**Subject:** Form completion: Planning Application Comments Form

*refNo:* 3/2021/0167

*addDev:* 2 Bridge End Whalley Road Billington BB7 9NU

PROPOSED PLANS

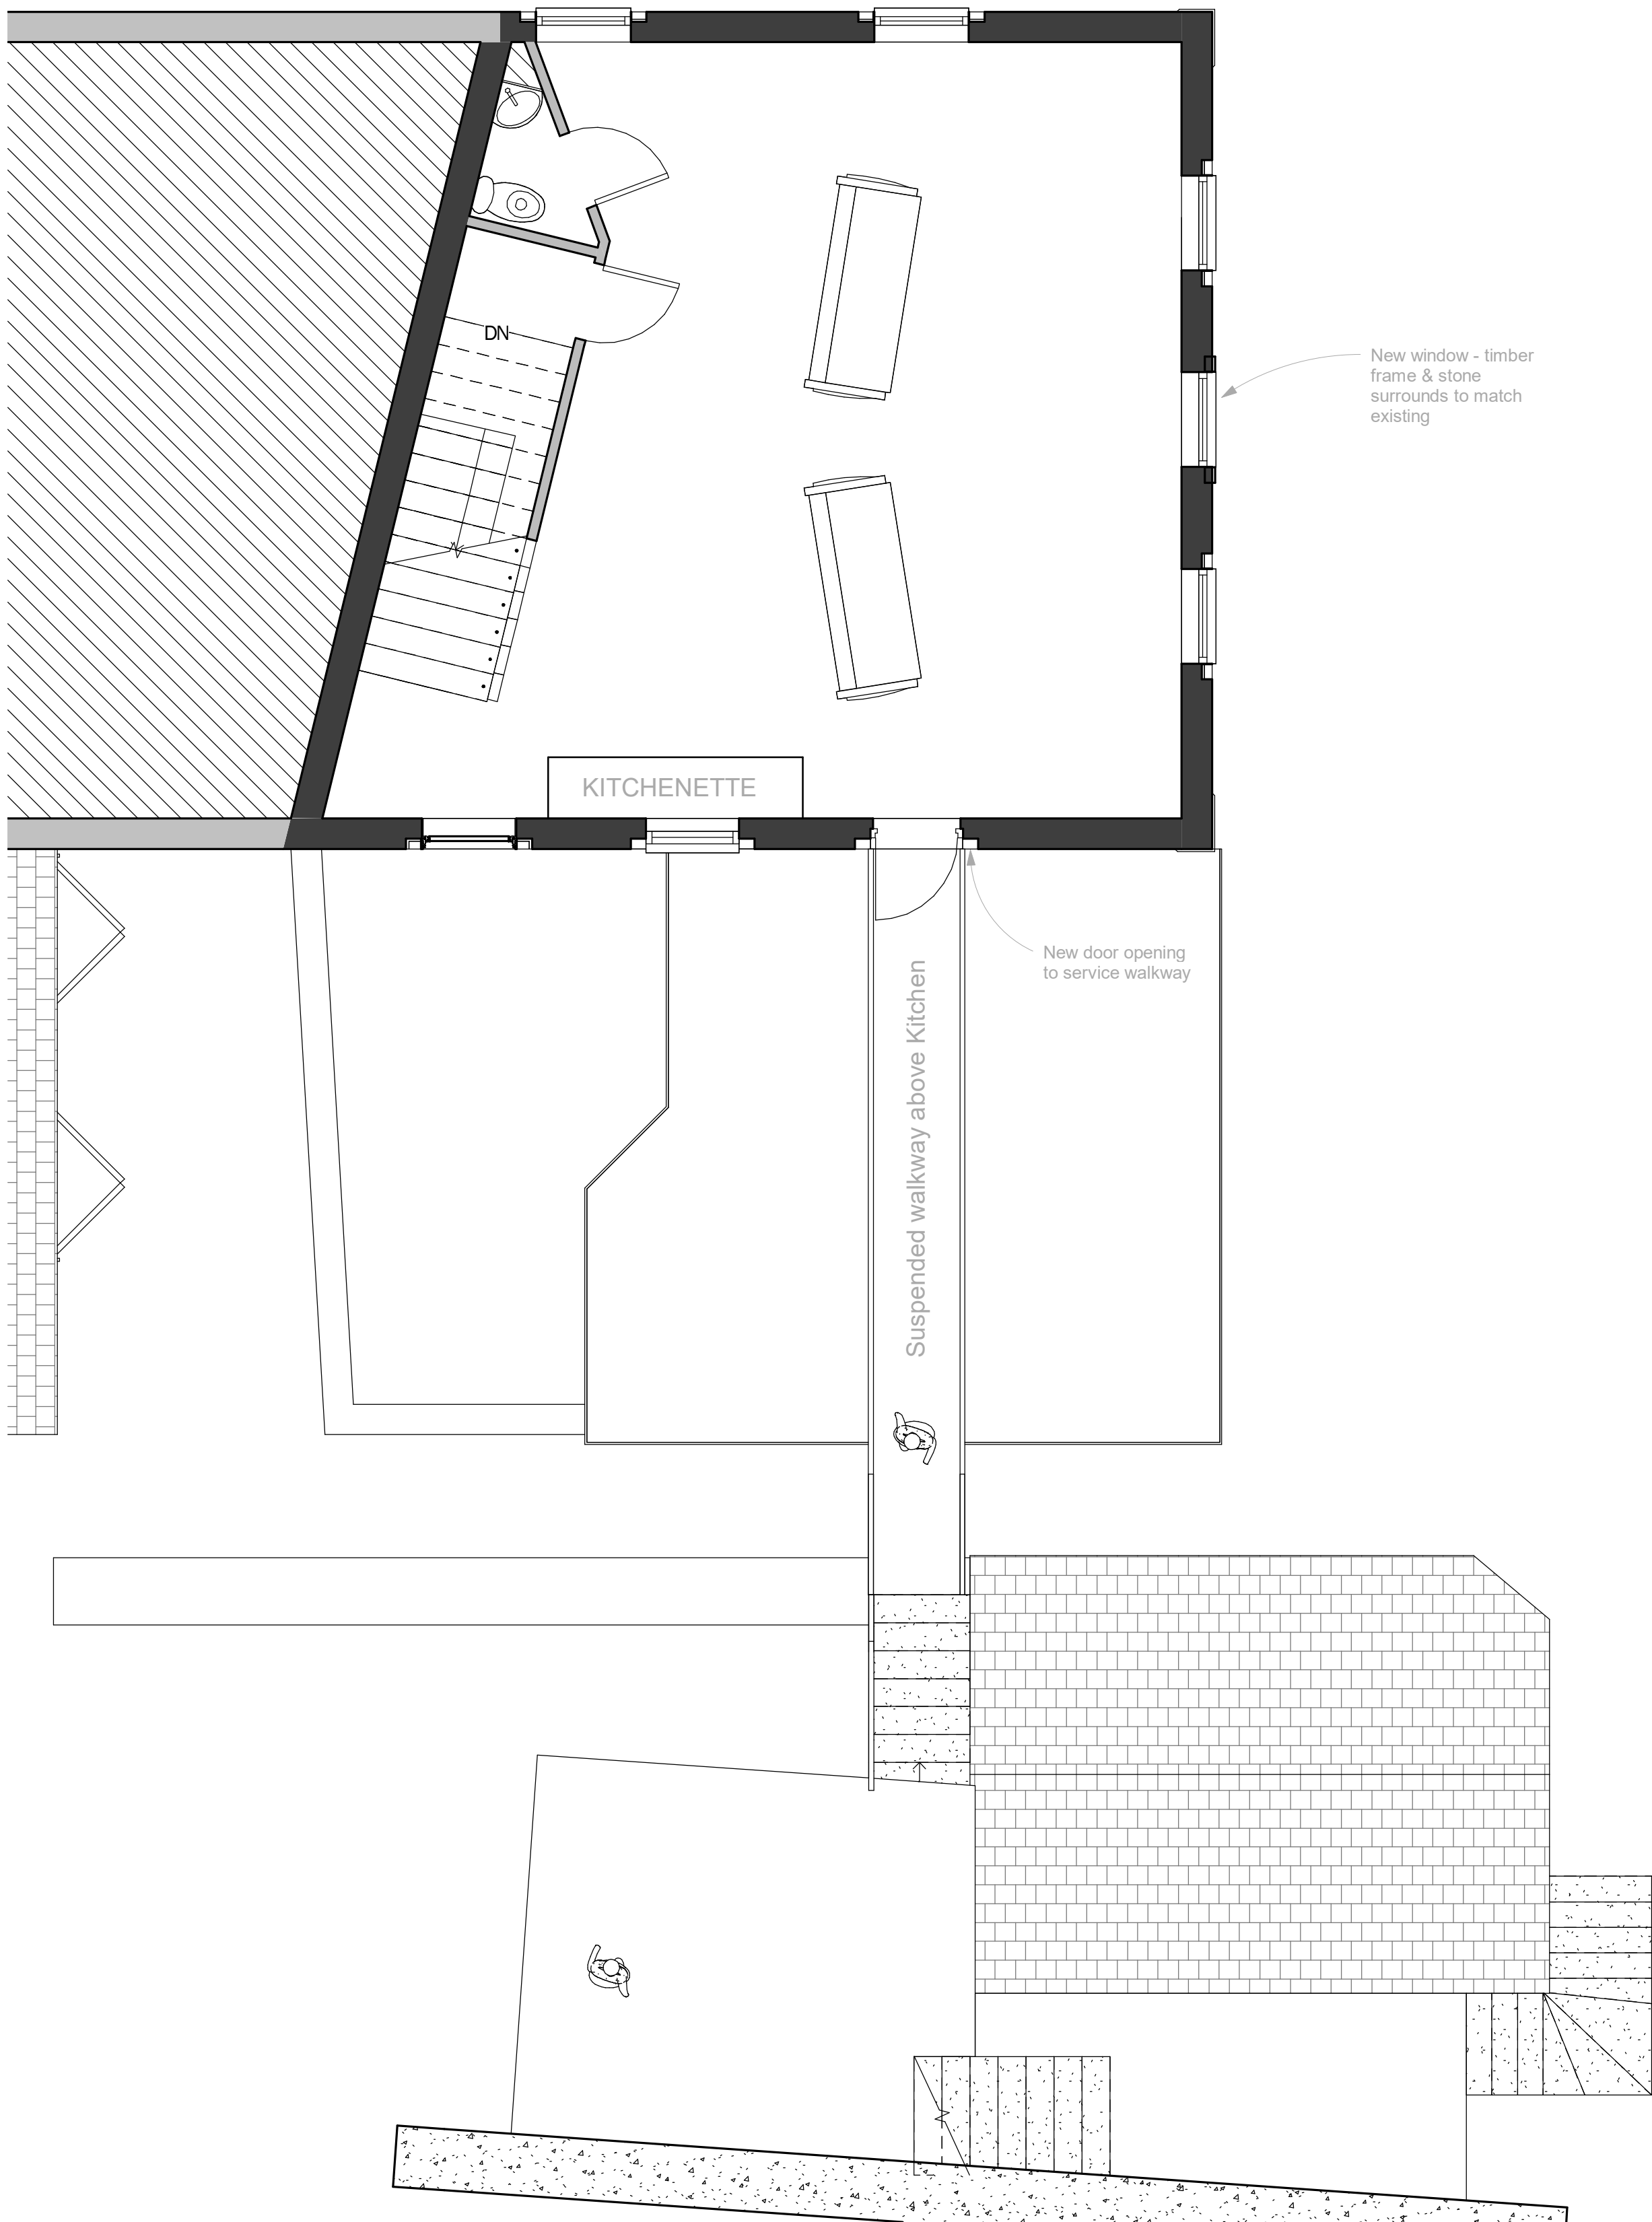
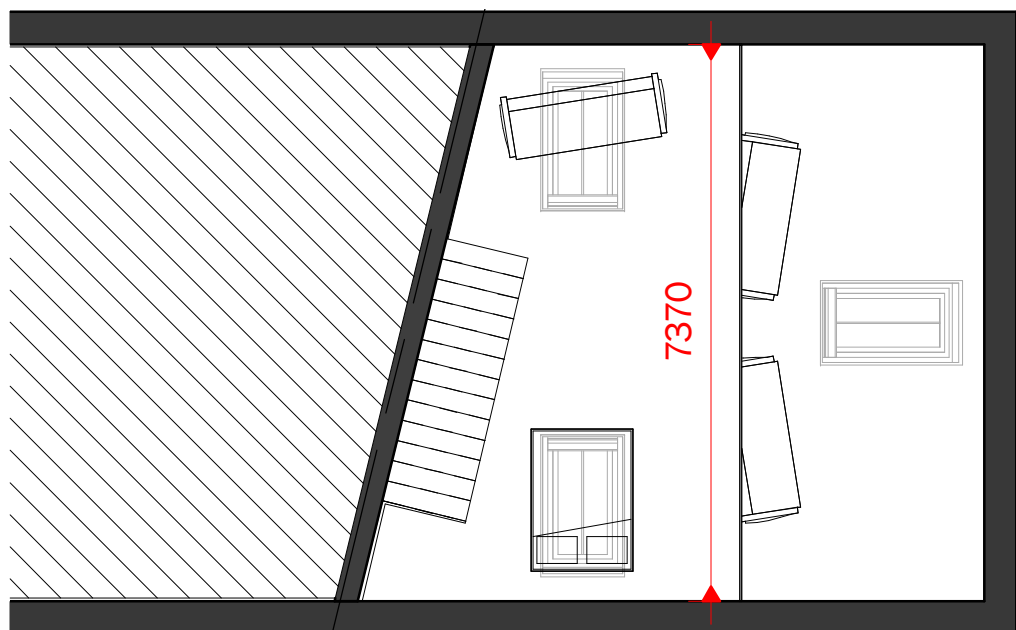
*comments:* I write to give comment on application number 3/2021/0167. The comments relate only to the external walkway aspect of development, along with a sun terrace shown on the drawings that does not benefit previous consent. â€¢ The red line submitted by the applicant is inaccurate. The adjacent property (4 Bridge End) owns the freehold interest of a part of the application site, comprising the rear passageway behind 2 Bridge End and also a significant element of garden space currently included within the applicantâ€™s red line. Land registry title documents numbered LA704864, LA770932, LAN161092 can be obtained from Land Registry and demonstrate this. The applicant does not own a freehold interest in any of the passageway to the rear. â€¢ The submission of certificate A is incorrect. The applicant should have served Certificate B on the owner of 4 Bridge End. This has not happened and consequently consent of this application would not be legal. â€¢ There are two title plans for 2 Bridge End numbered LA704864 and LA770932. Whilst a garage has been extended with consent into land included within the second title deed (previously agricultural), the land within that deed cannot be accessed directly from the land originally linked to the domestic property. It has no benefit of change of use to form garden space for 2 Bridge End. The land within the second title is accessed from what is assumed to be council land on Moor Lane. â€¢ There is no right of way to access the land to the rear through the passageway and no airspace lease is granted to the air above. â€¢ A new hardstanding within the land to the rear has been established within the last 12 months after structural-works, previous to this the earth was collapsed and not accessible for some 12

months. The application cites a sun terrace, there has been no continuous use of the hard standing at the rear as a sun terrace for 10 years and no certificate of lawfulness has been awarded. Therefore, the sun terrace cited as existing is unlawful. It is generally accepted that balconies, roof gardens and first floor patios can adversely affect the privacy of neighbours and can be deemed unacceptable. The hardstanding to the land at the rear has serious overlooking implications on the dining room, kitchen and rear yard of 4 Bridge End. This appears to contravene policy H10. If this space is connected to the domestic property directly as an active garden, the situation will be amplified. Note withdrawn application number 3/2008/102 includes parish council comments that reference a proposed roof terrace to Number 2 as detrimentally affecting Number 4. The withdrawn application was re-submitted without terrace. The bridge link increases the extent of overlooking beyond that within the withdrawn application. The underside of the proposed walkway will create a hiding space within the curtilage of 4 Bridge end on the rear approach to the dwelling. The rear is utilised in normal circumstances daily. The fence currently in place is for the Health and Safety benefit of the occupier whilst the wall to the rear is rectified after collapse due to a flood event. The proposed high-level walkway to Number 4 will create a space susceptible to antisocial behaviour and leave the occupants of Number 4 vulnerable to attack. Please note that I do not oppose the principle of the application in regard to the interior of the dwelling, but the overall design detrimentally affects the right to privacy, quiet enjoyment and accessibility of Number 4 Bridge End.
